Gatwick Airport Northern Runway Project

Appendix B – Response on Landscape and Ecology

Application Document Ref: 10.65

1 The Applicant’s Response to Deadline 7 Submissions on the Draft DCO

ORIENTATION 	DRAWING NO. <b>FIGURE 3.3.1</b>	REVISION For ES Issue
	DRAWN BY <b>MS</b>	PM / CHECKED BY <b>NB</b>

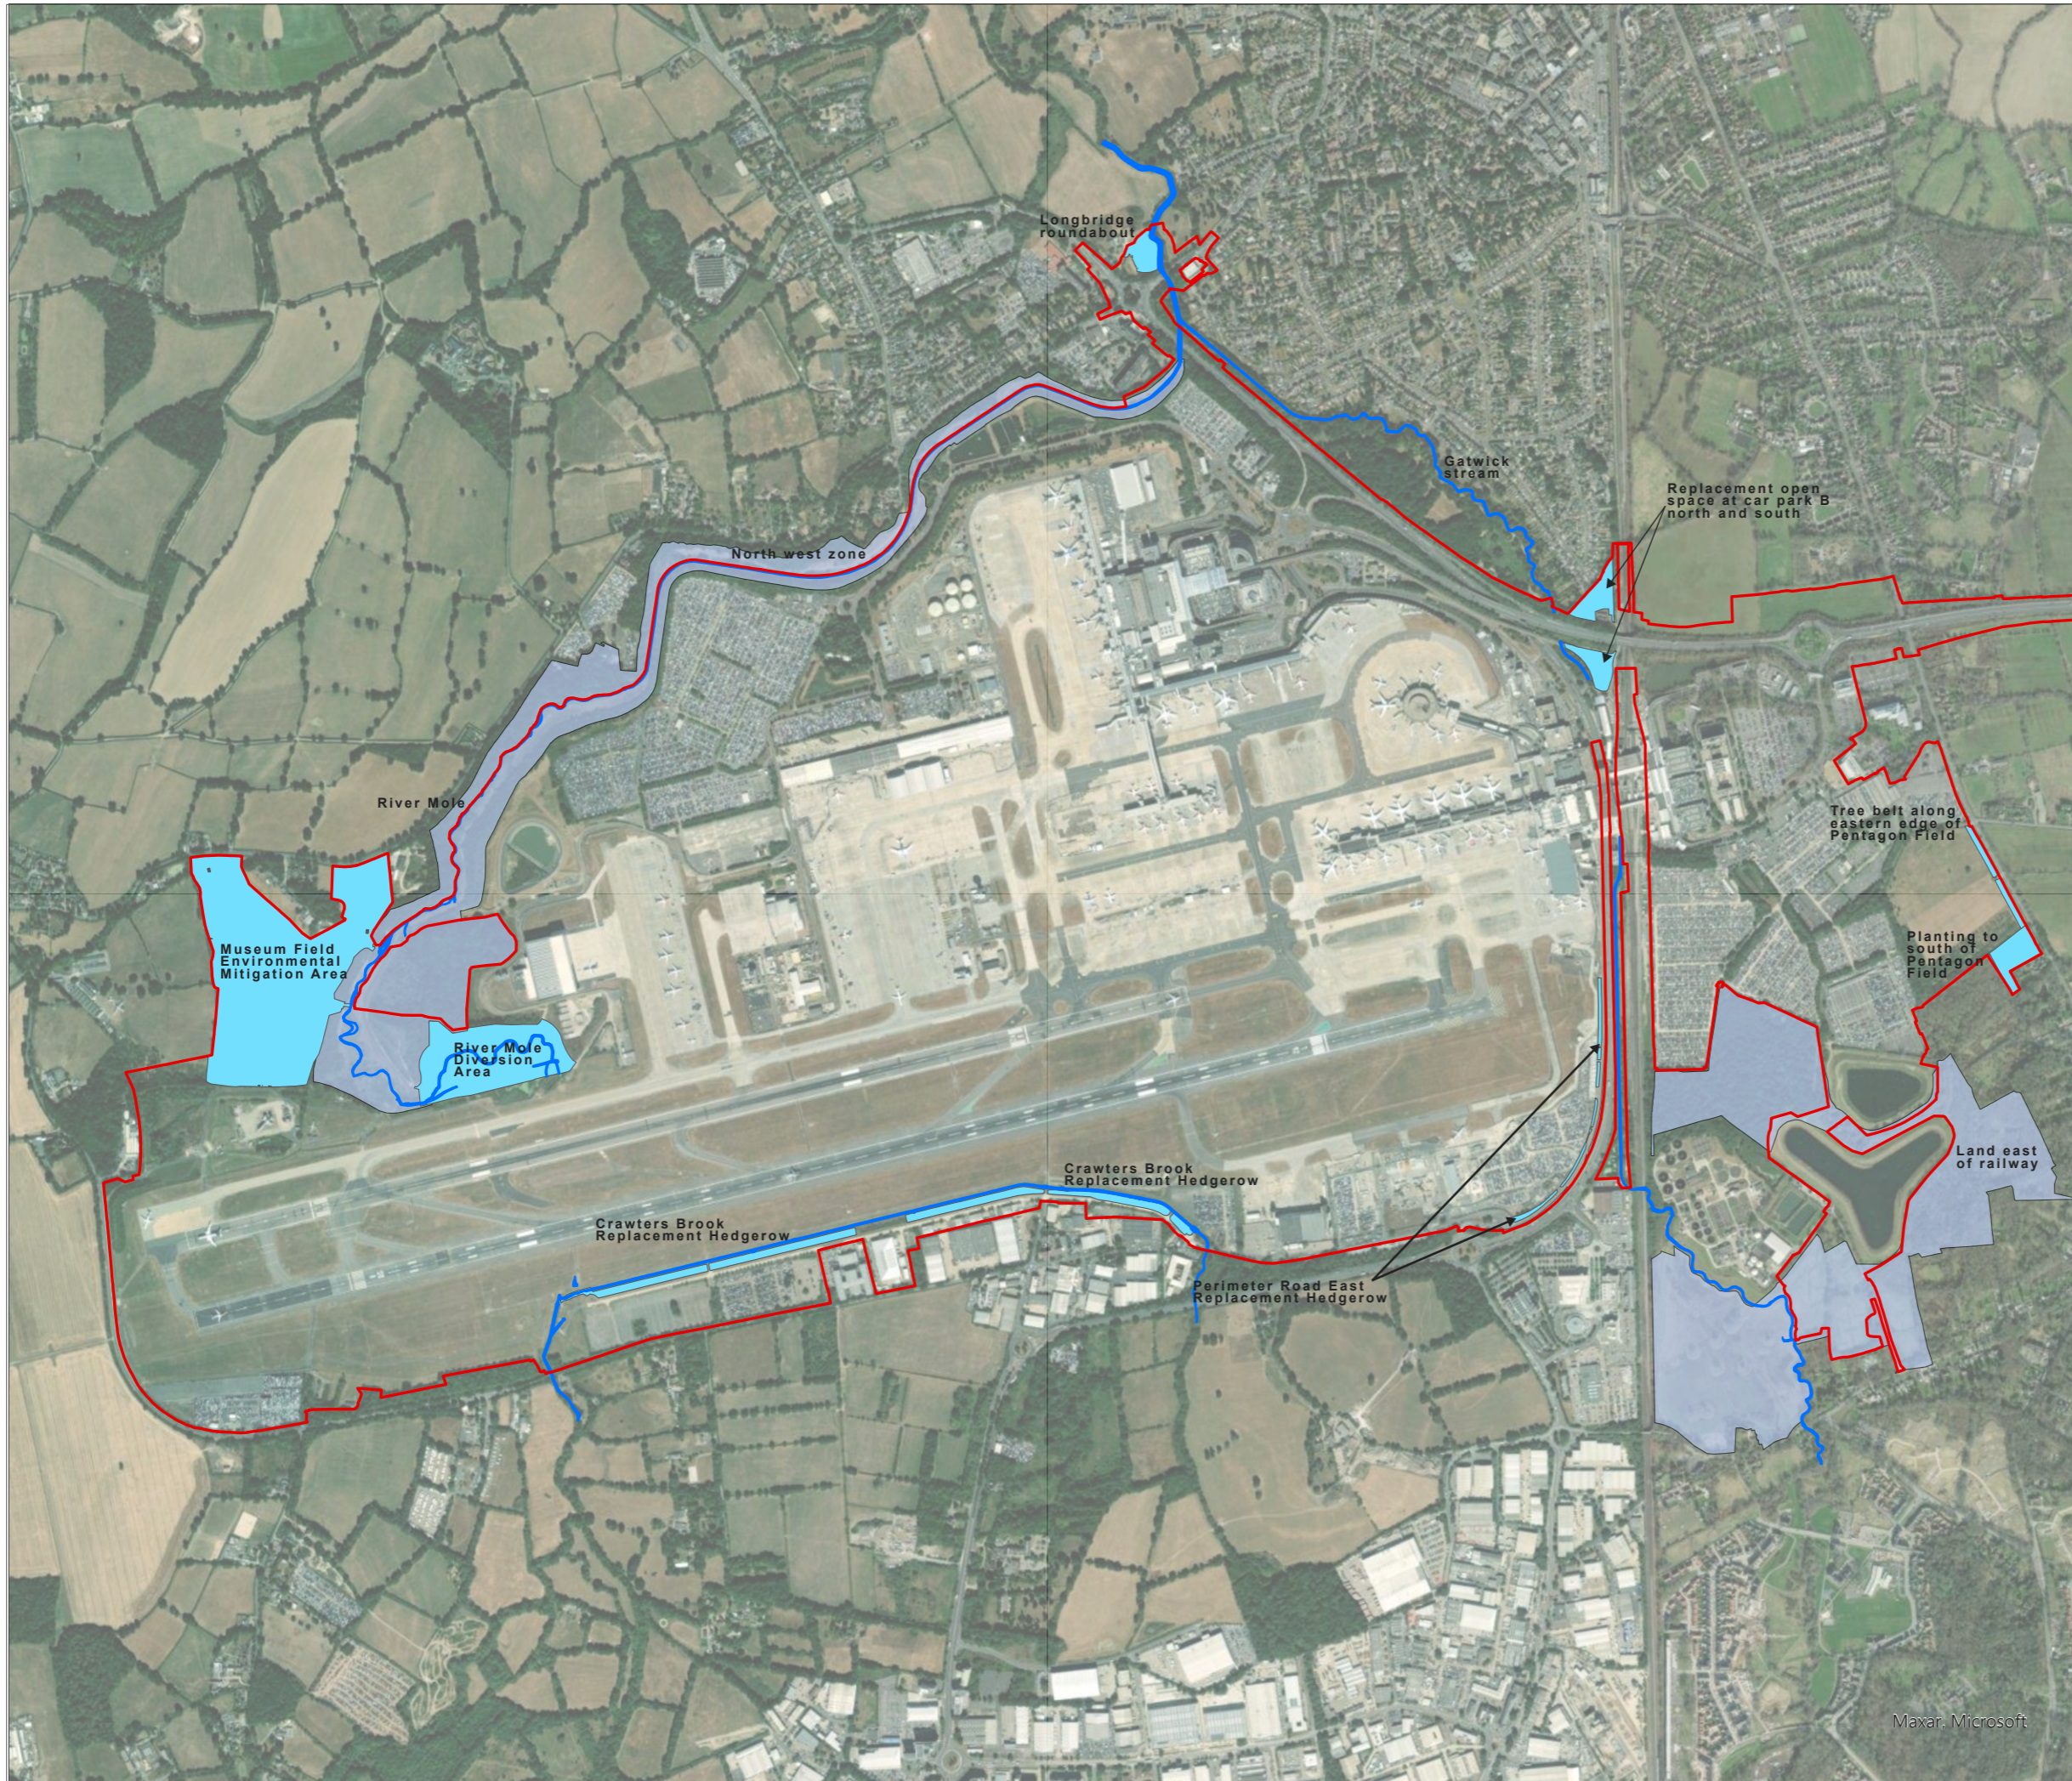
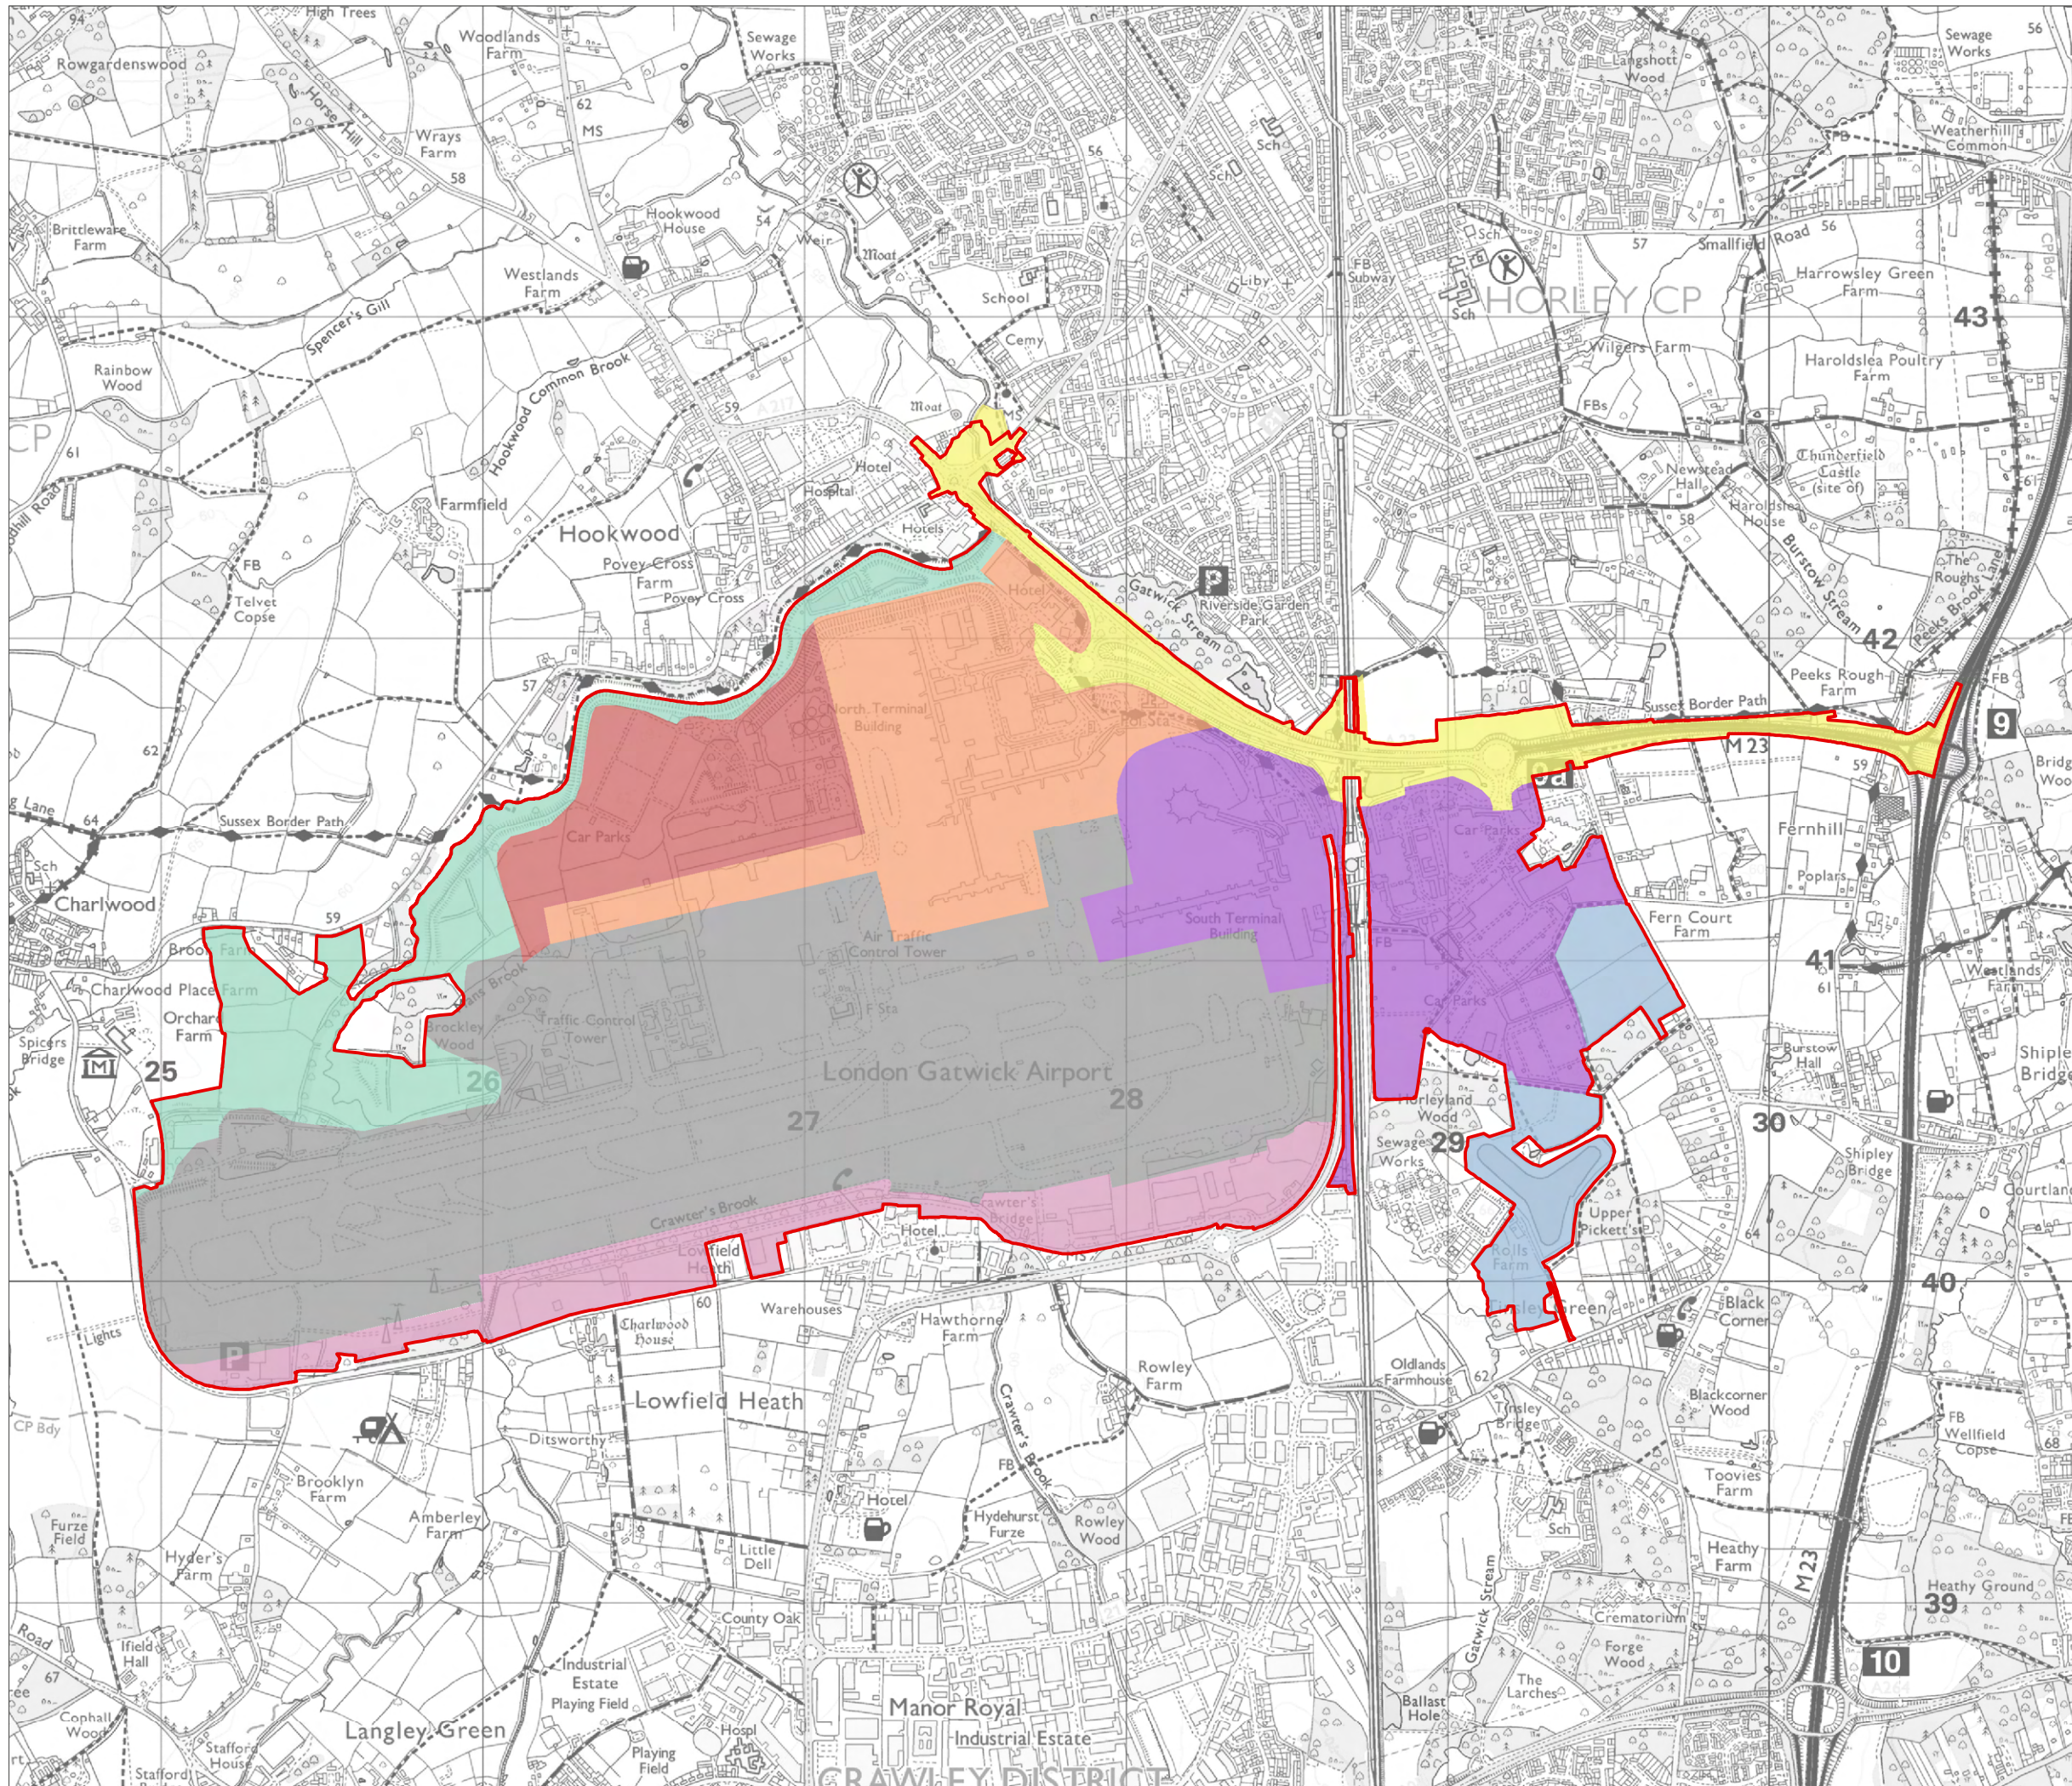
| 4.1 | There is confusion as to whether Pentagon Field is to be regarded as an ‘Environmental Mitigation Area’. Surprisingly it does not feature as such in Figure 3.3.1 (Indicative Ecology Strategy) dated July 2023 within | The planting of the woodland strip along the eastern side of Pentagon Field is shown on the Indicative Ecology Strategy (Figure 3.3.1 of the oLEMP) because it has been relied upon in the Landscape and ecology assessments of the Environmental |

| <p>the oLEMP Part 2 [REP6-034] yet sections 1.2.2 and 6.5.7 of the oLEMP Part 1 [REP6-032] state that Pentagon Field will deliver ecological mitigation or enhancement.</p> <p>Also, section 2.3.3 of Note on Project-Wide Habitat Loss and Replacement, June 2024 [REP6-071] refers to the creation of enhanced neutral grassland in Pentagon Field post development. If indeed Pentagon Field is to be reinstated as enhanced neutral grassland, it would be helpful if this could be made clear in all documents, including Figure 1.2.18 (Pentagon Field Sketch Landscape Concept) of the oLEMP Part 2.</p> | <p>Statement, namely in ES Chapter 8: Landscape, Townscape and Visual Resources [APP-033] and ES Chapter 9: Ecology and Nature Conservation [APP-034]. In this context, it is only this strip which is regarded as a "formal environmental mitigation area".</p> <p>The grassland within Pentagon Field has not been relied upon in the assessments in ES Chapter 8: Landscape, Townscape and Visual Resources [APP-033] and ES Chapter 9: Ecology and Nature Conservation [APP-034] and therefore is not considered part of a "formal environmental mitigation area".</p> <p>Paragraphs 1.2.2 and 6.5.7 of the oLEMP (Doc Ref. 5.3) make clear that the planting areas which have been included specifically as mitigation or enhancement for the Project include the native woodland strip along the eastern side of Pentagon Field (adjacent to Balcombe Road).</p> <p>In relation to the grassland to be reinstated as enhanced neutral grassland, the Applicant has updated Figure 1.2.18 of the oLEMP at Deadline 8 to support the JLA's in their understanding as requested.</p> |
